Mr Brent Lawson
The Trustee for Minto Property Trust
PO Box 7108
Silverwater New South Wales 2128
26 November 2020

**Minto Resource Recovery Facility (SSD-5339)
Response to Submissions**

ATTACHMENT 1

DRAWING TITLE SITE LOADING & UNLOADING PLAN				
PROJECT NO. P1203464	PLANSET NO. PS02	RELEASE NO. R21	DRAWING NO. PS02-DZ10	REVISION F

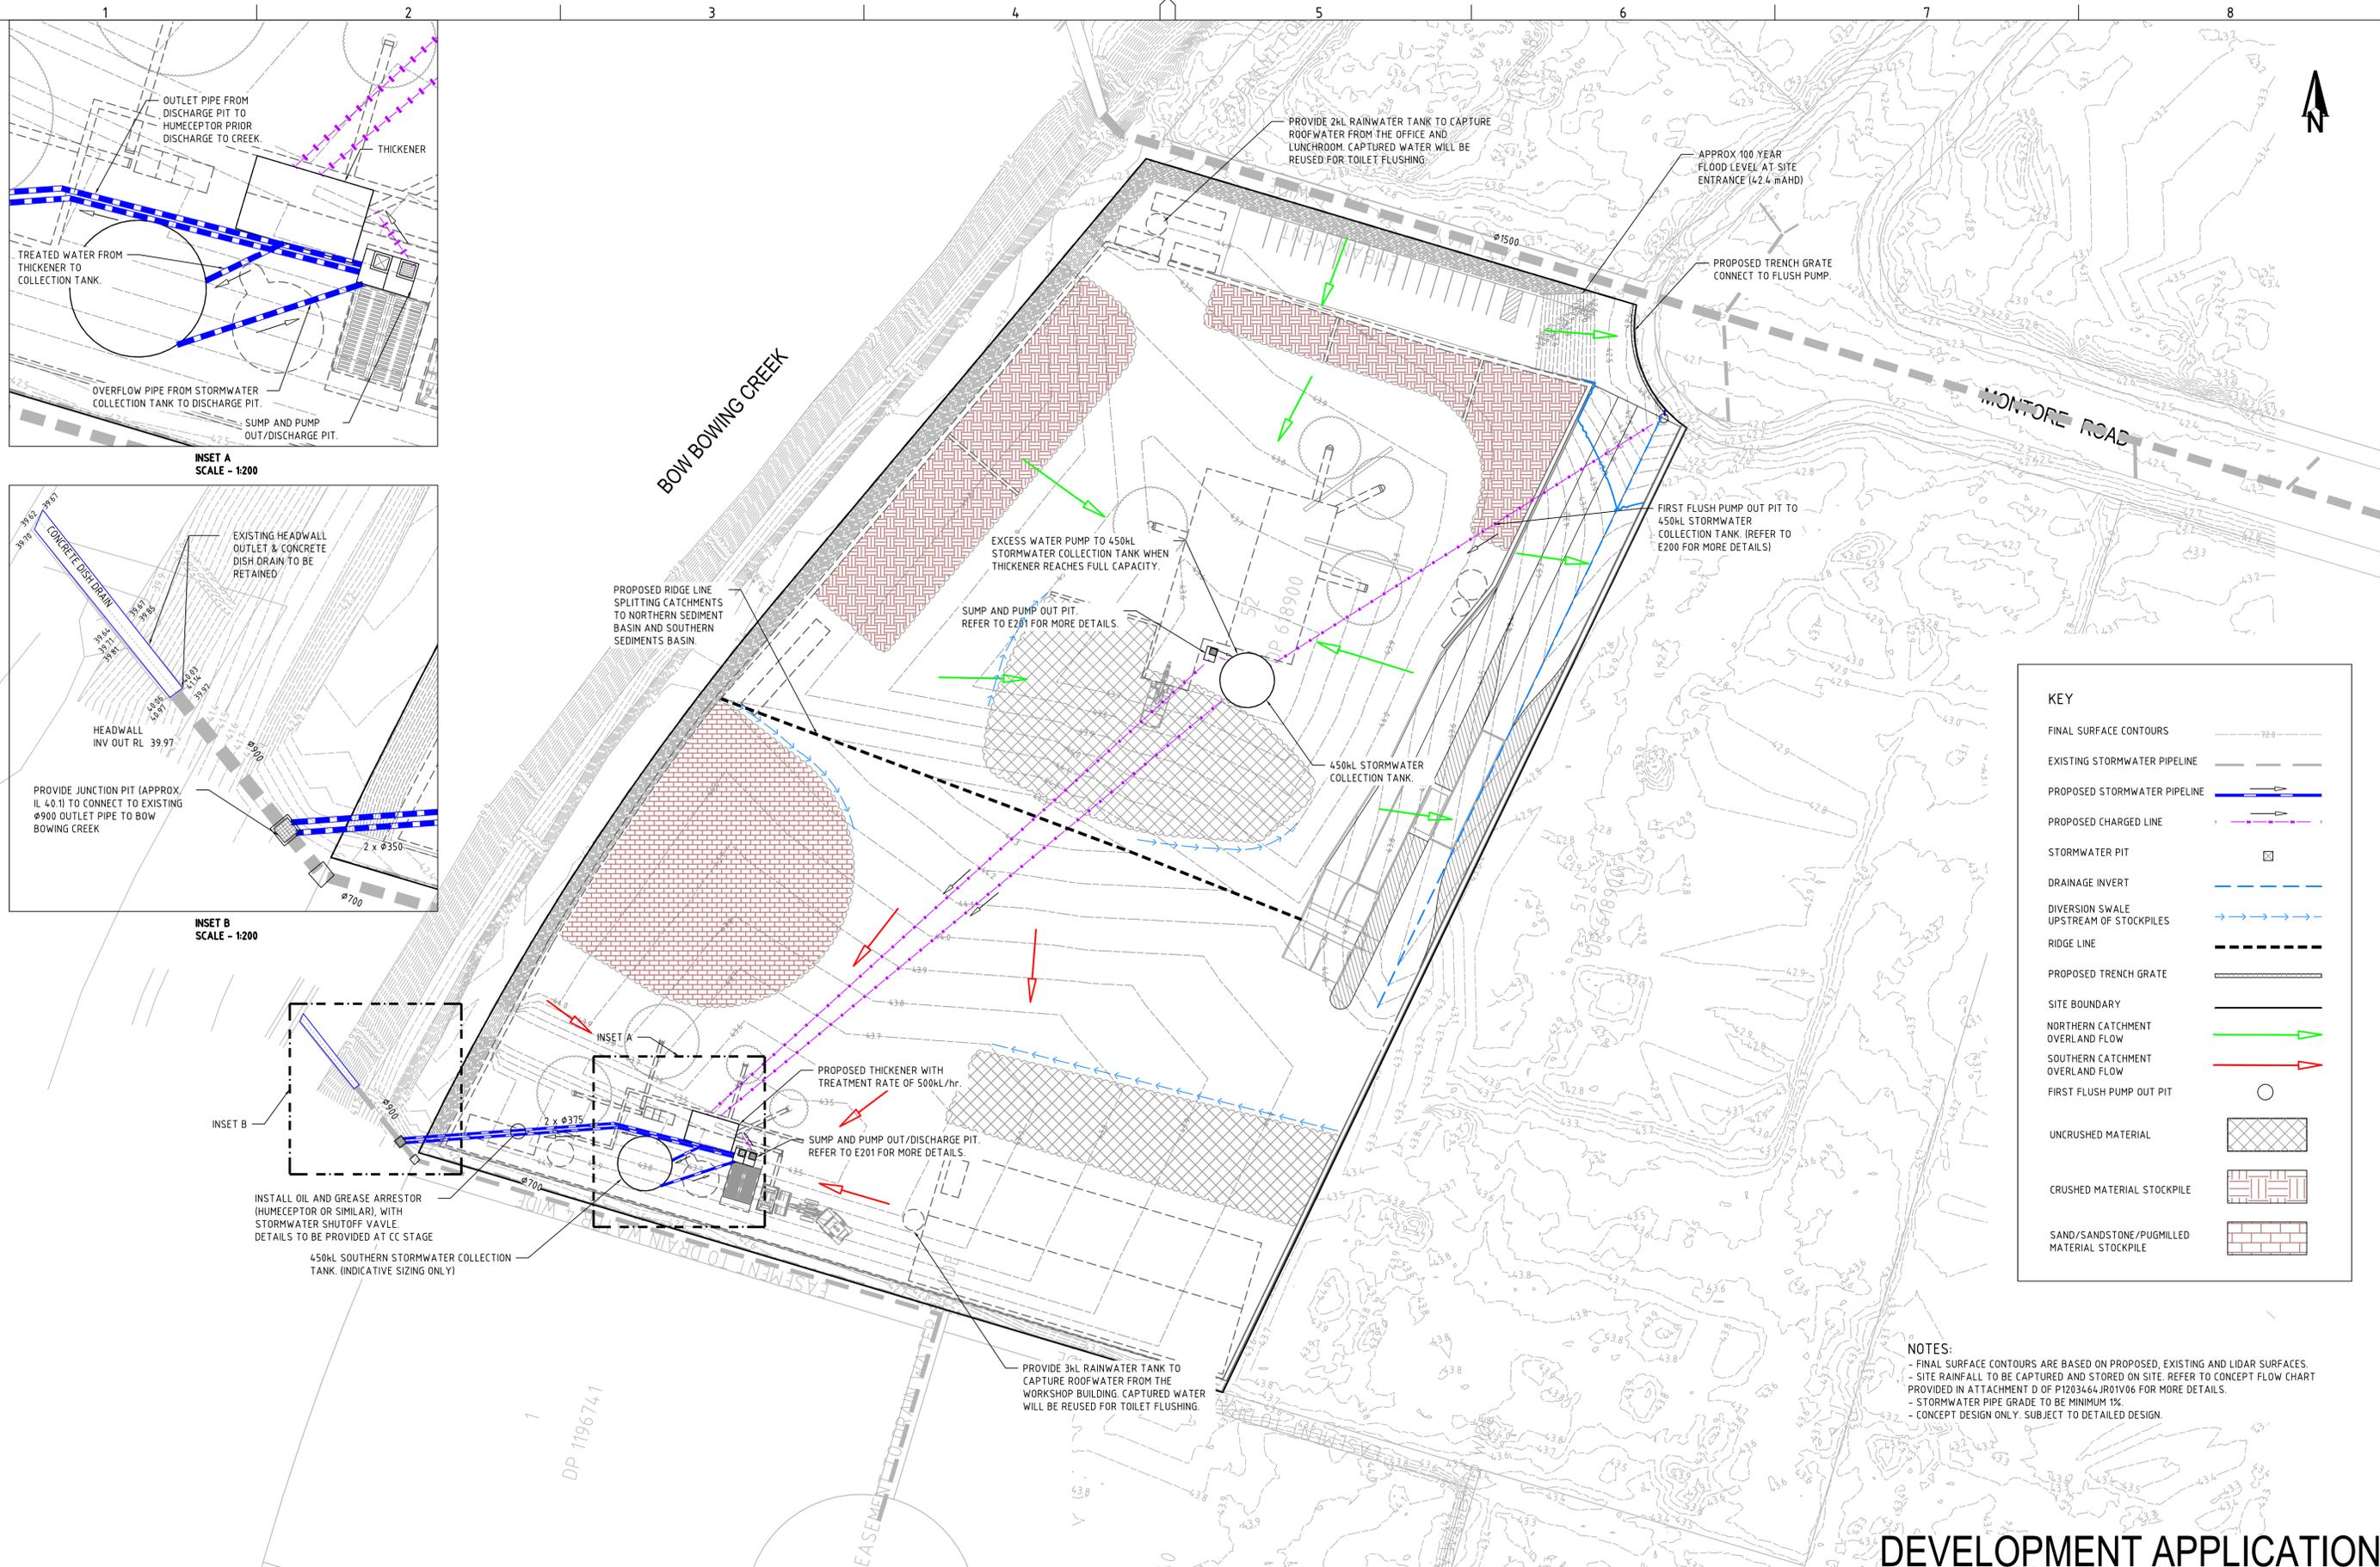
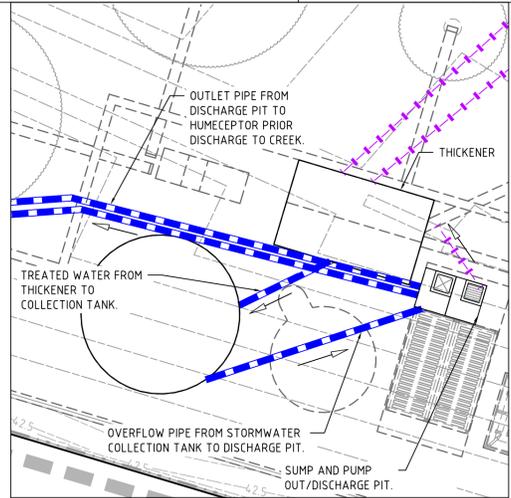
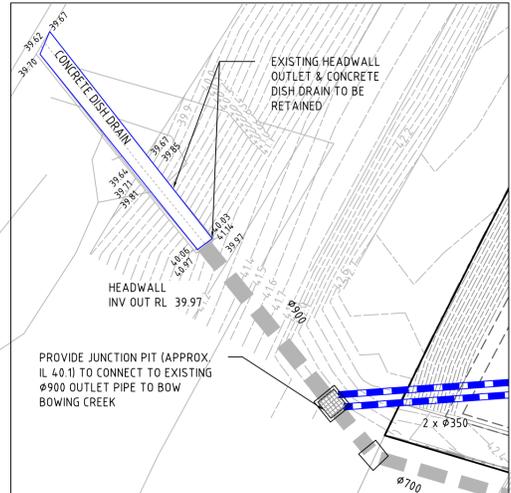
- It is noted that a one-way system for traffic has been provided, however, the swept path analysis Drawing PS02-DZ01 indicates heavy vehicles would occasionally undertake a U-Turn, please demonstrate that this movement will not interfere with the unloading/loading operations.

DRAWING TITLE				
DRIVEWAY PLAN				
PROJECT NO.	PLANSSET NO.	RELEASE NO.	DRAWING NO.	REVISION
P1203464	PS02	R21	PS02-F101	F

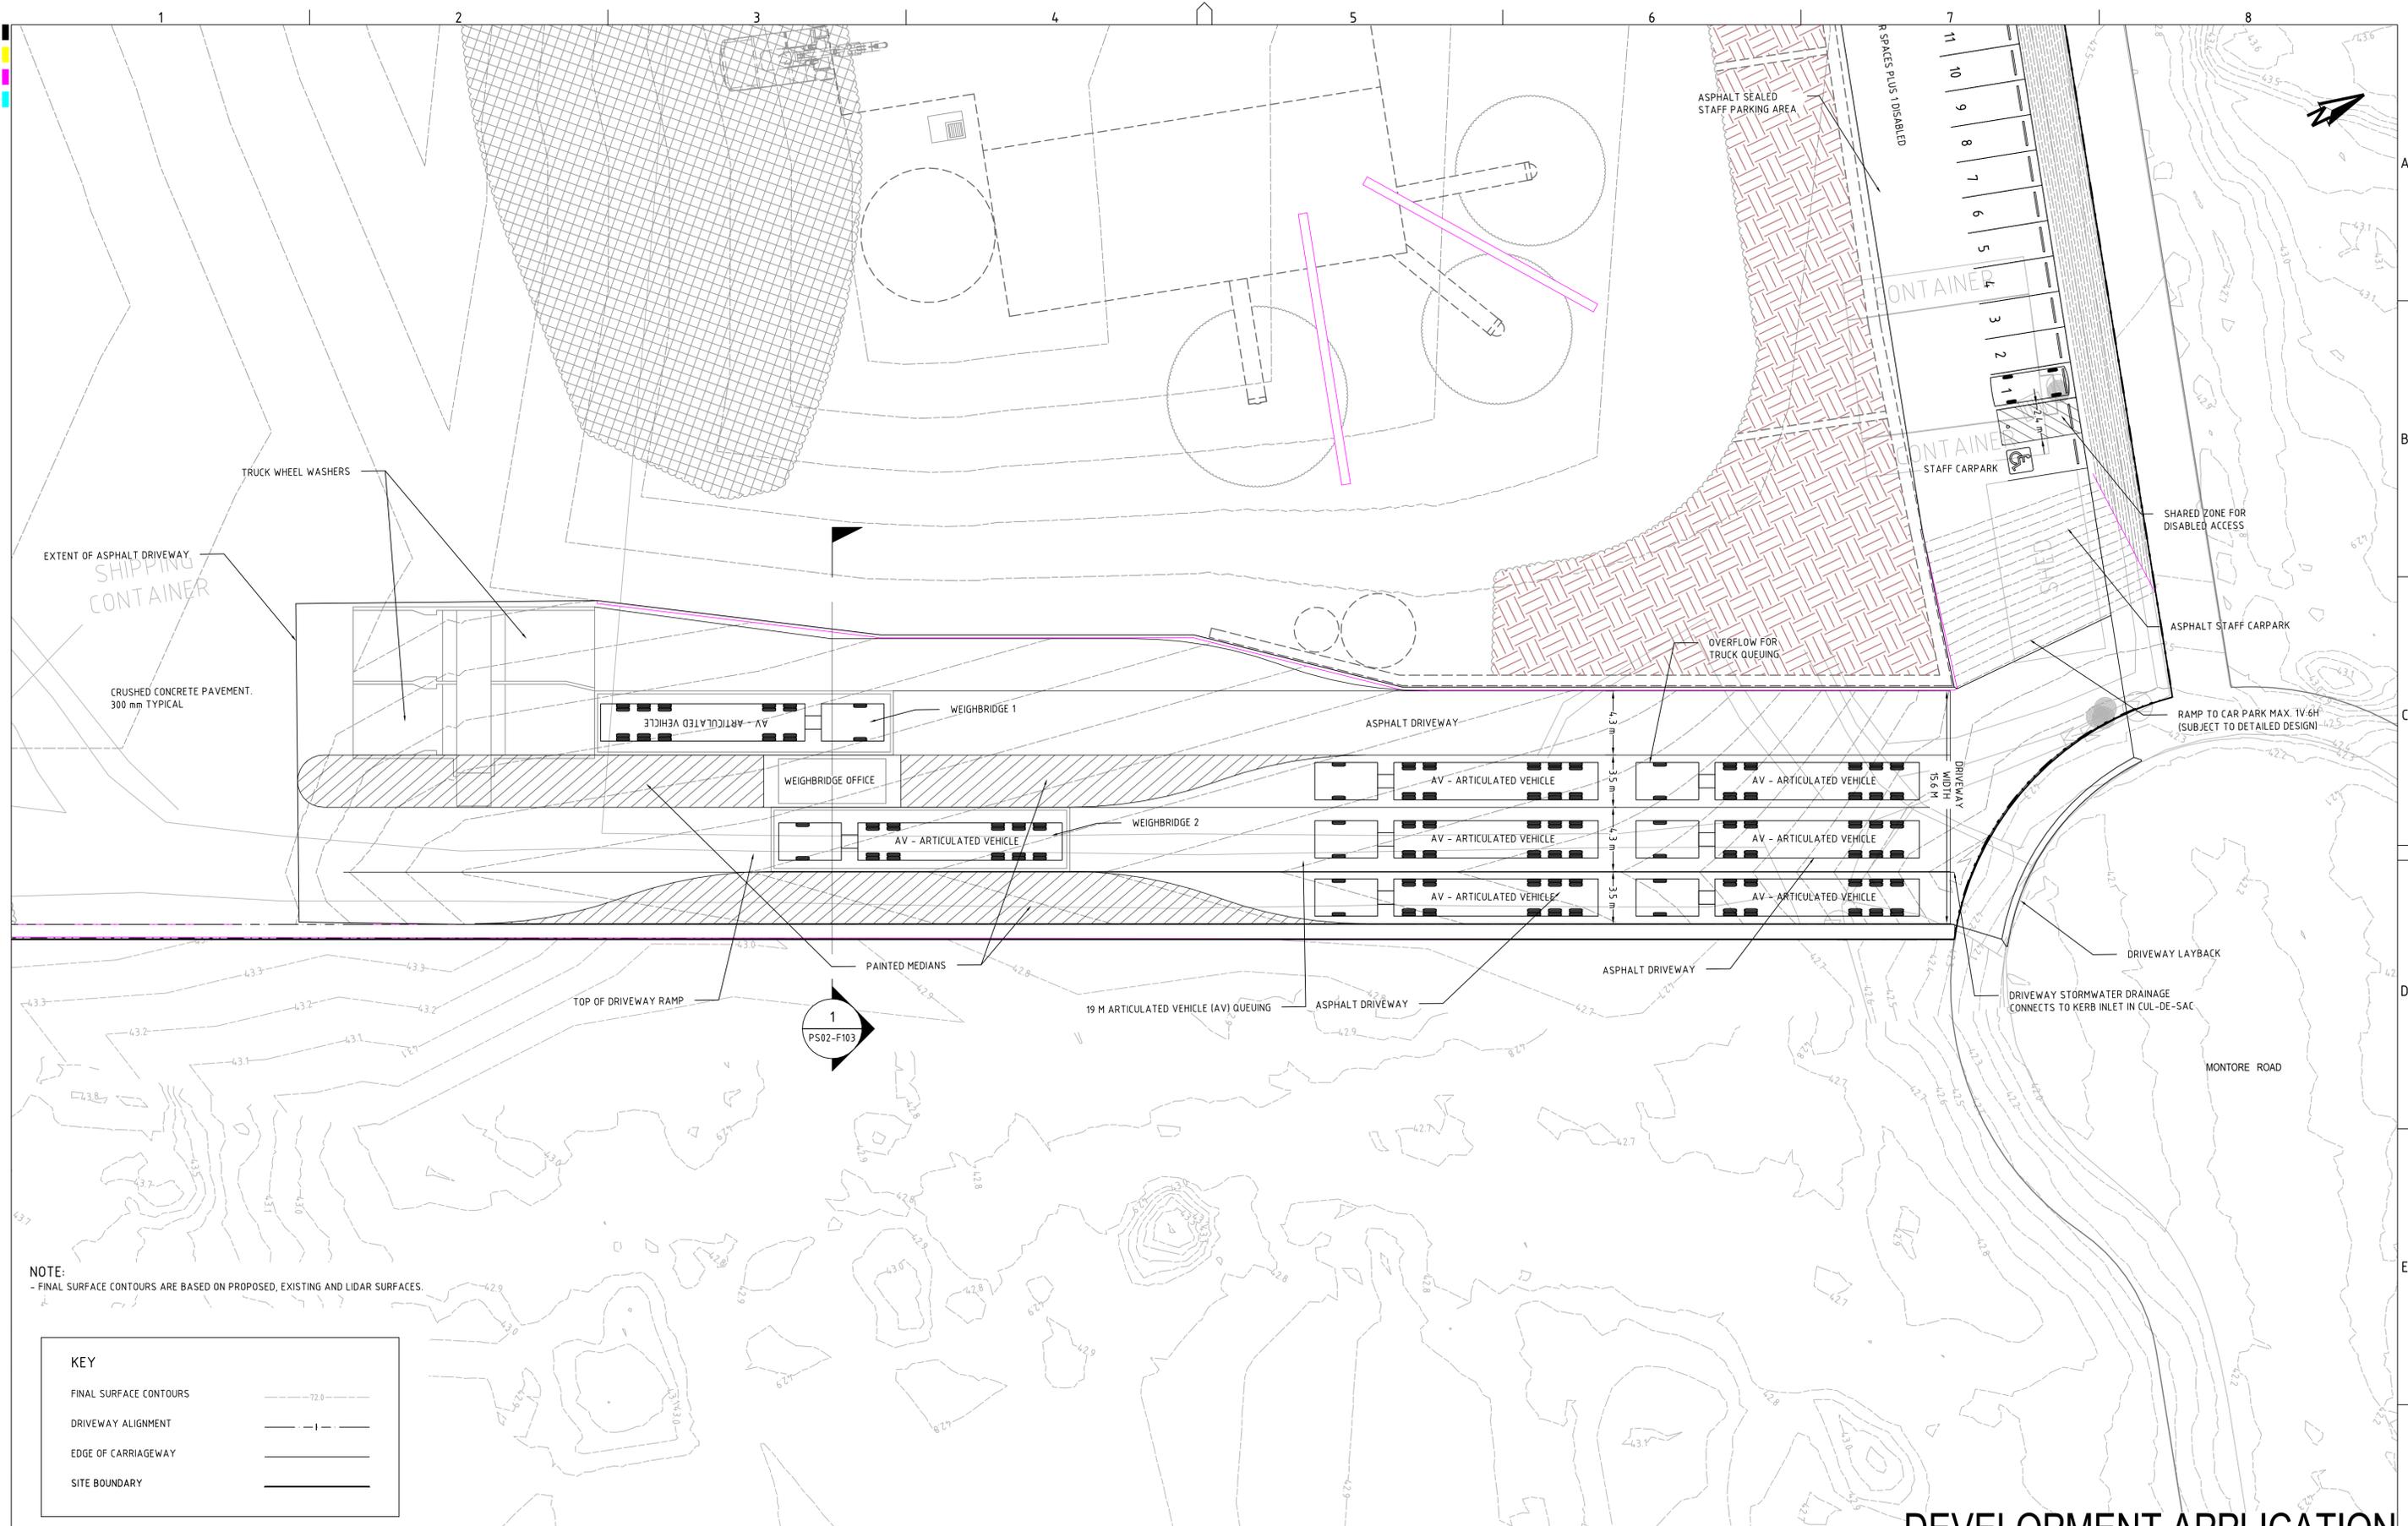
- It is understood that a new driveway/access way would be required to accommodate the development. Please describe the new access and provide the relevant engineering drawings.
